DeLUCA-HOFFMAN ASSOCIATES, INC.  
CONSULTING ENGINEERS

**Subject: Convenience Store and Fuel Station Development  
2282 Congress Street  
Final Site Plan Application  
Response to Review Comments Associated with April 23, 2013 Submission**

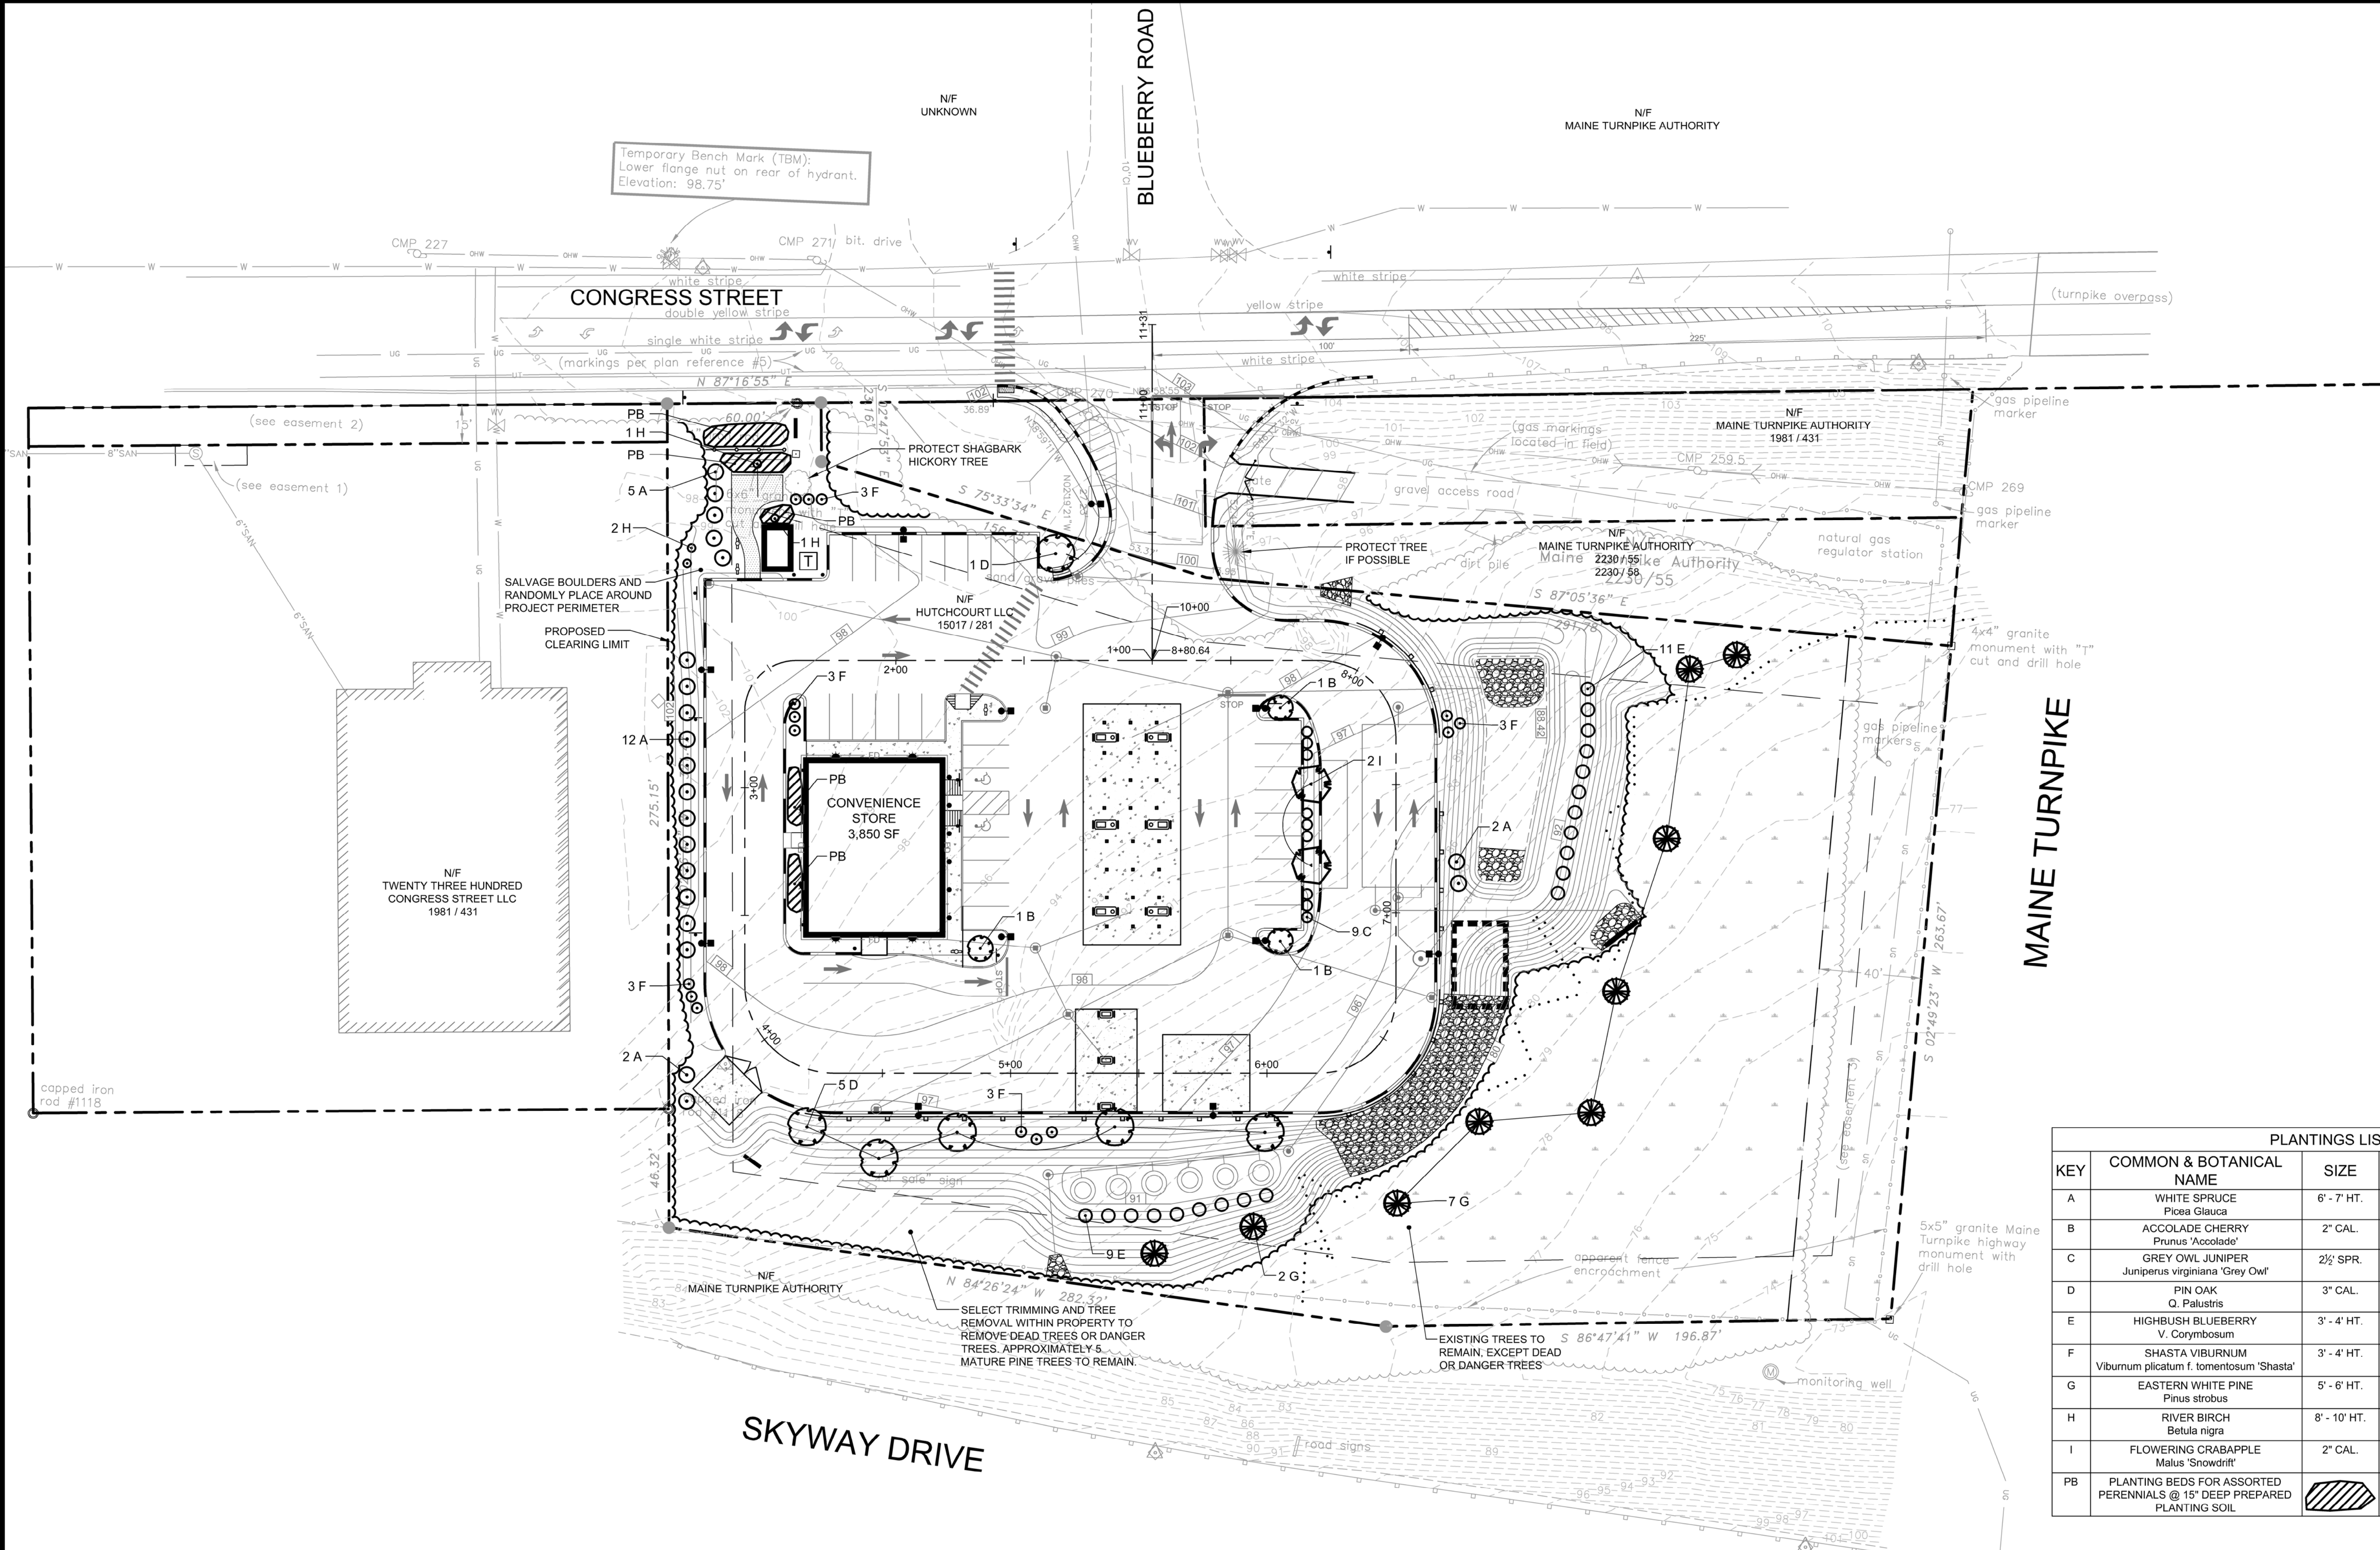
*The recent landscape plan increases the tree planting and campus feel as requested, however would like to offer the following recommendations / conditions:*

- a) ***Congress Street Edge*** – *In the location of the proposed 'picnic area' would like to see a greater amount of tree save / thinning then clearing. The existing birch trees and native vegetation can be thinned to allow for the garden, the value of the screening and tree save is a higher value in regards to the overall landscape function. I can meet with the applicant project team if helpful.*

*b) **Tree Saves** – I would like to see a greater attempt to save the mature existing trees along the project edges. These White Pine in particular offer important structure to the current landscape feel. Reducing the pavement edge along the west & Skyway Drive edge by either narrowing the driveways / parking lot or shifting the built development away from the edges. The tree save areas should be shown or mentioned on the plan and protected in the field following our standard 'tree-save' recommendations. This would include the area along Congress Street and the important Shagbark Hickory.*

*c) **Additional Trees Along the Parking Lot** – In the area near the stormwater feature the recent plan did not show the additional trees requested. Having trees and/or shrubs is important so this area does not appear void of vegetation. We should be able to resolve this with an additional grouping of three to five trees. I can meet to review this condition as well if needed.*

Our office has revised the landscape plan between the picnic area and Congress Street to require selective trimming in lieu of clearing. The plan also requires a pre-clearing meeting is held with the contractor.

The plan has been modified to address the concerns adjacent to Congress Street (including the Shagbark hickory).

Although the site plan has been modified to reduce impervious area by about 7.6%, it is not recommended by our office that the development area is shifted easterly because of the additional natural resource and clearing impacts that would occur as a consequence. The landscape plan does propose replacement of trees along the westerly boundary.

The area in the southwest (Skyway Drive) corner is noted to be an area of select trimming and clearing only.

The revised plan provides an additional 5 trees along the easterly pavement edge between the pavement and the stormwater management facility.
